Lancashire Gardens Trust
Conservation & Planning Group

Planning Application No: 3/2013/0478

Listed Building Consent for the installation of single glazed hardwood framed windows and doors to the first floor level of the Bowling Green Café Clitheroe Castle, Castle Gate, Clitheroe

Drawing	Proposed Elevations	
Project	Bowling Green Cafe Castle Grounds Clitheroe	
Scale	Dwg. No.	Revision
1:50	BGC/ET/002	
Date	Drawn By	Checked By
01/13	T.L.

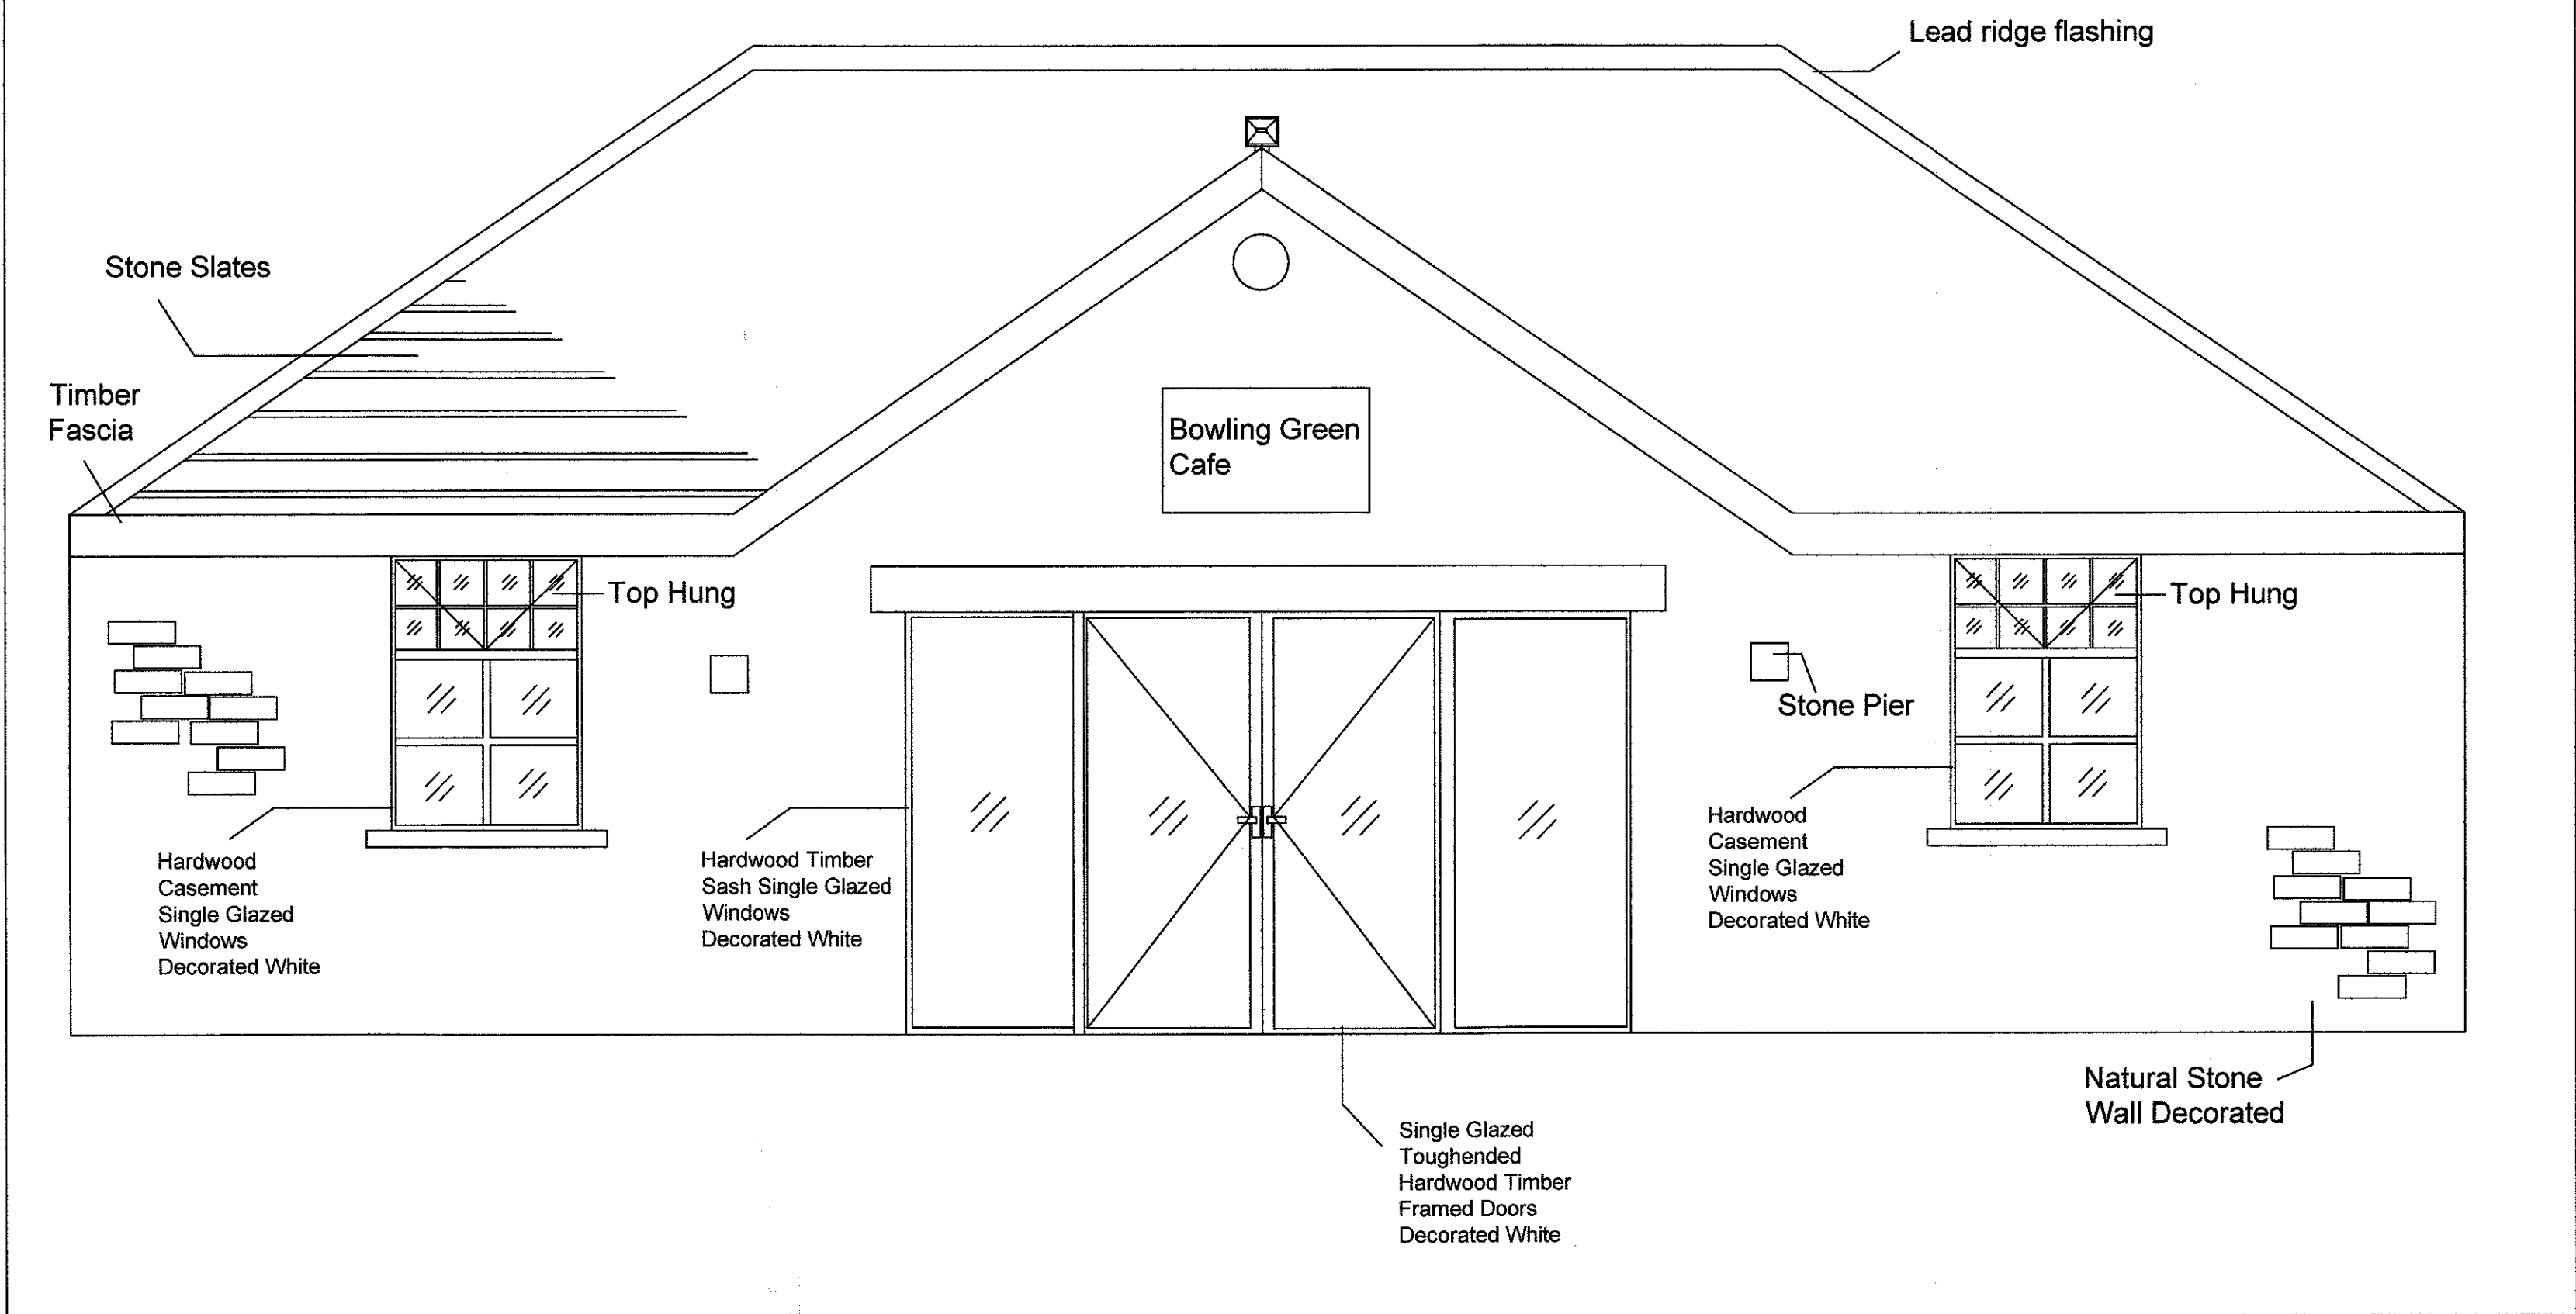
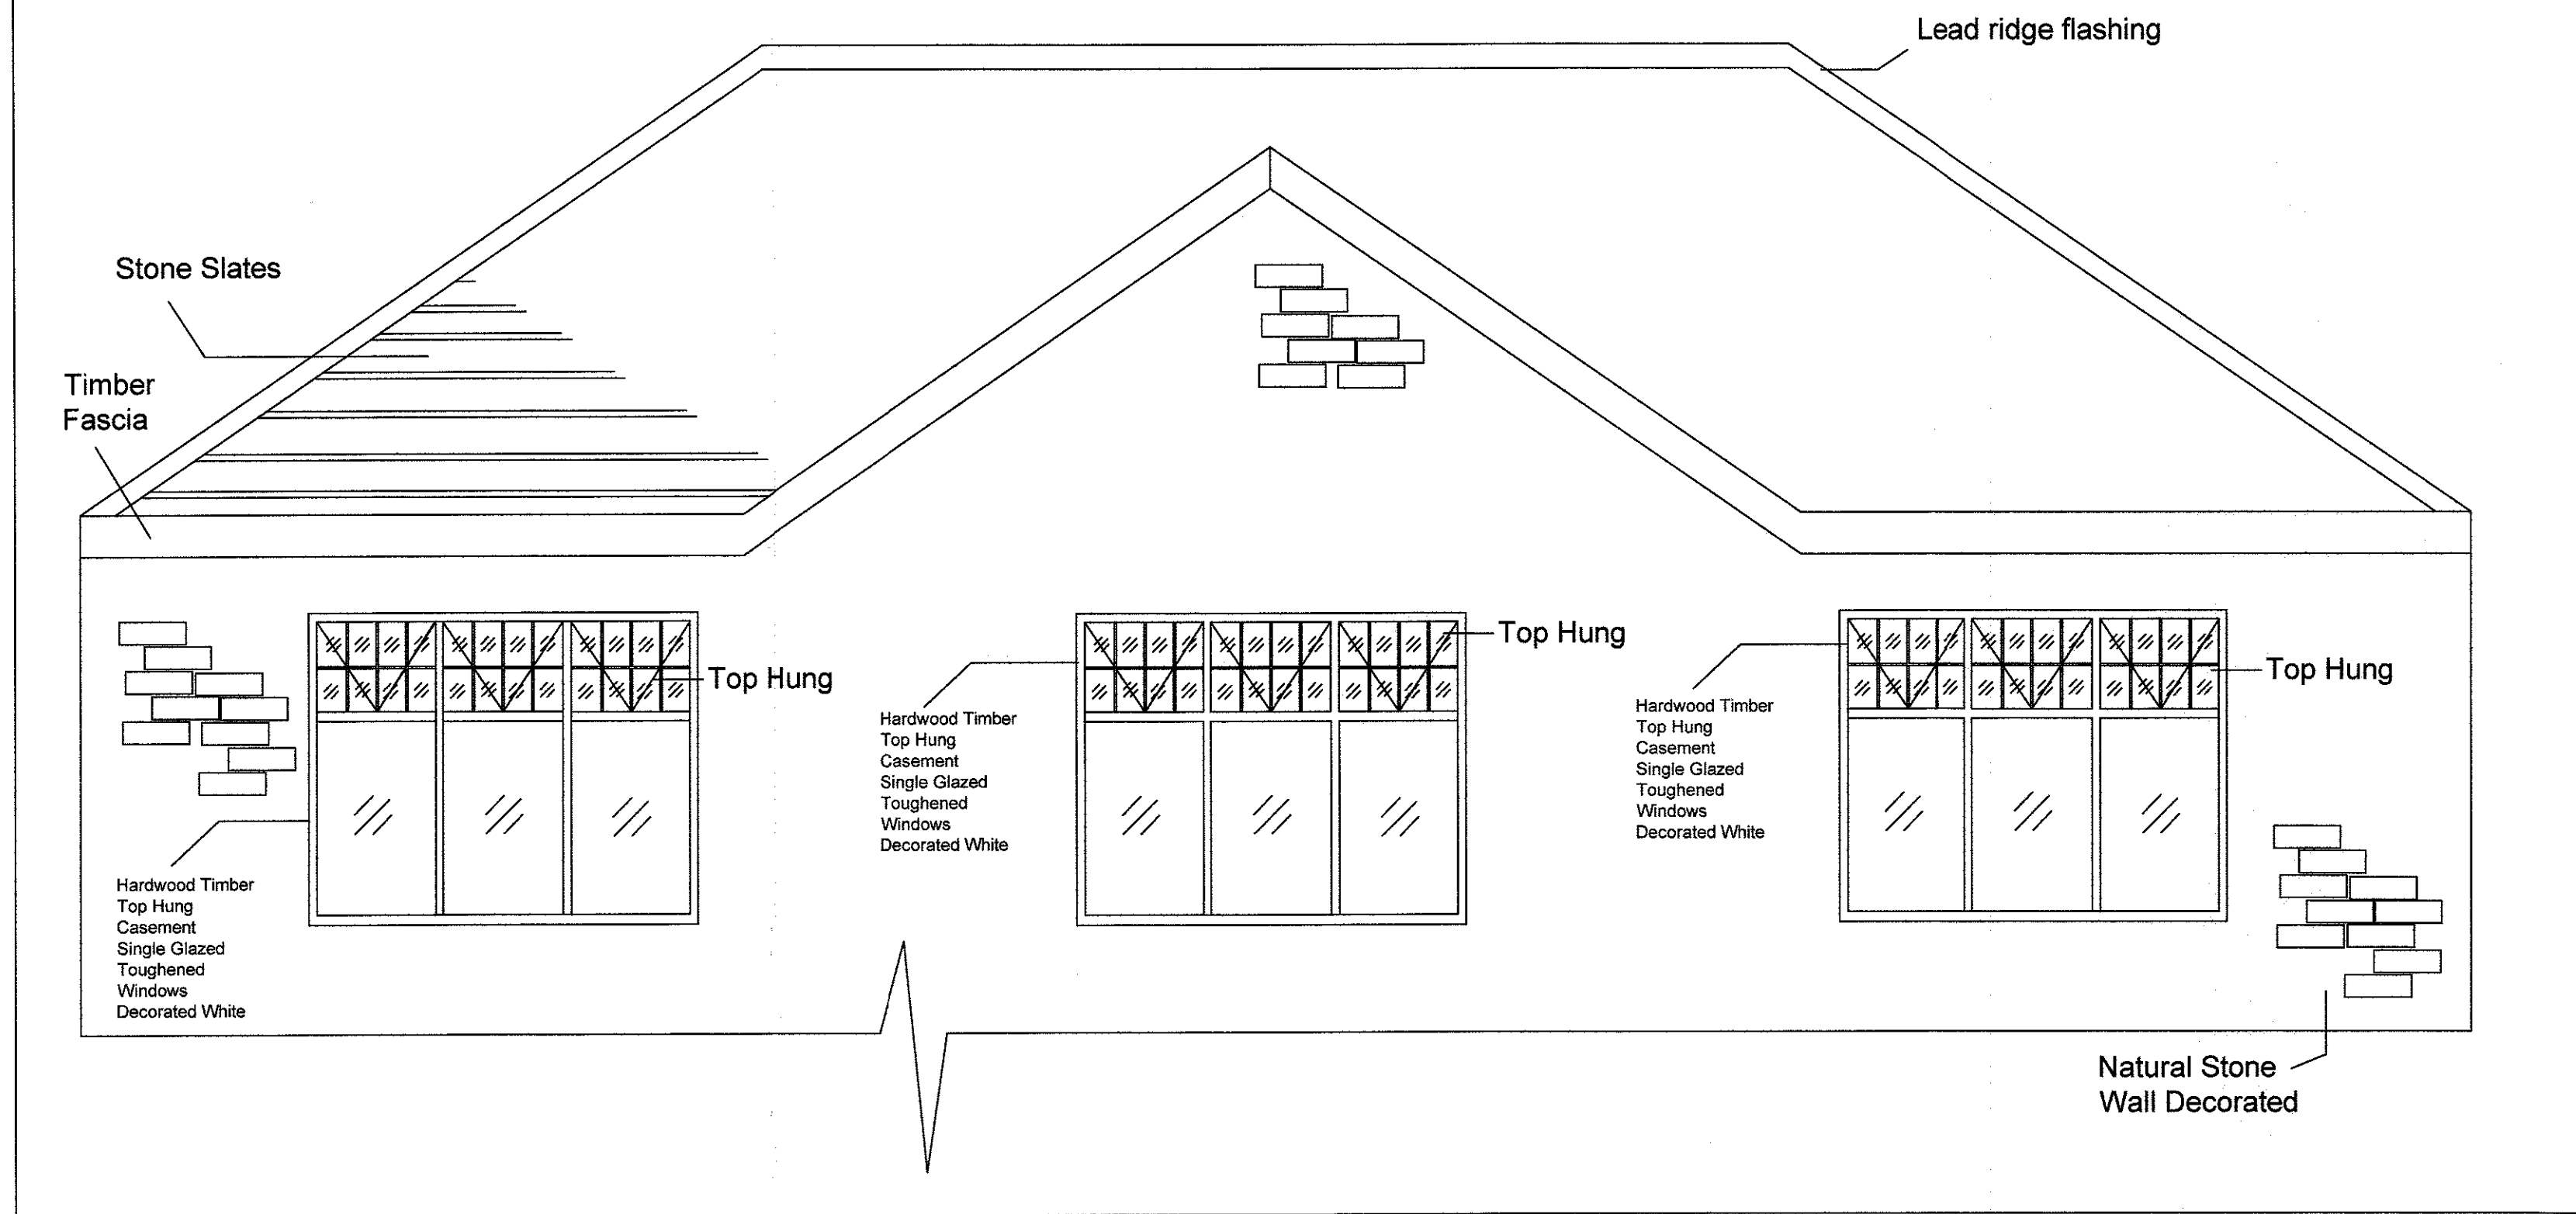
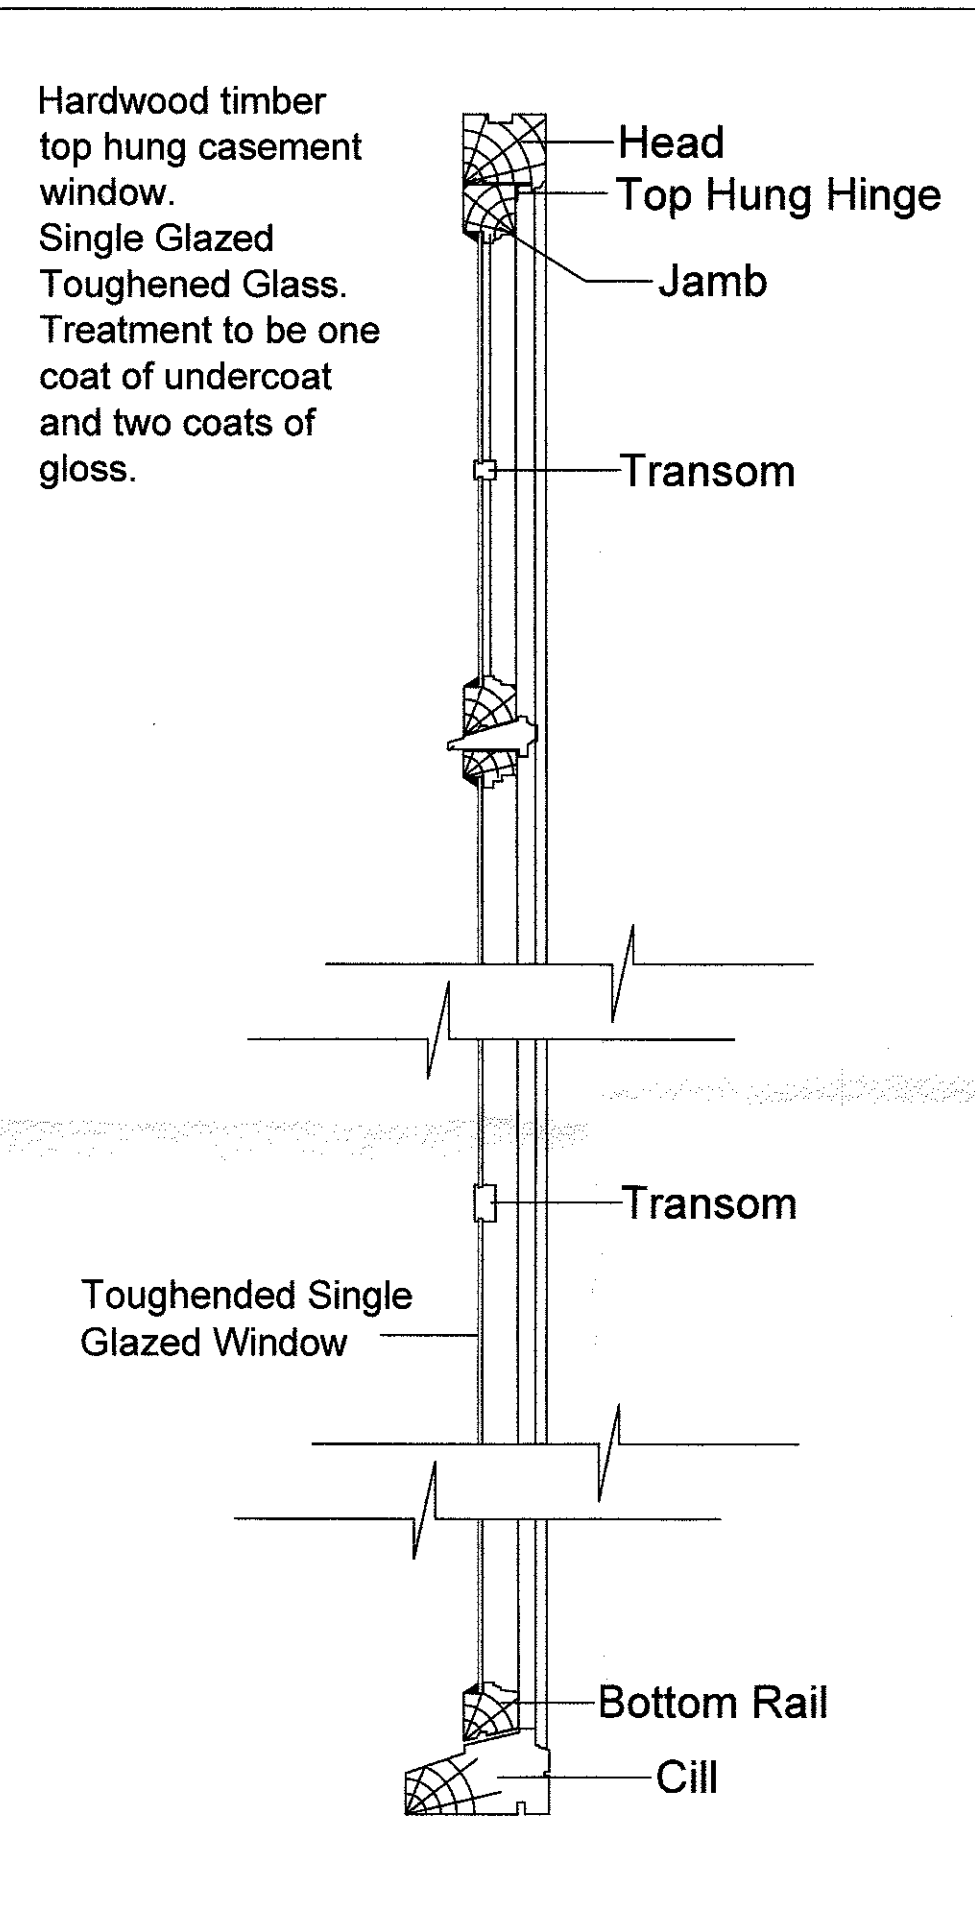
It is noted that this application is for relatively modest changes to the windows and doorway to the upper floor only of the café. The use of single glazed windows as opposed to more efficient double glazing is surprising, however, the replacement of the existing PVCu frames is welcomed.
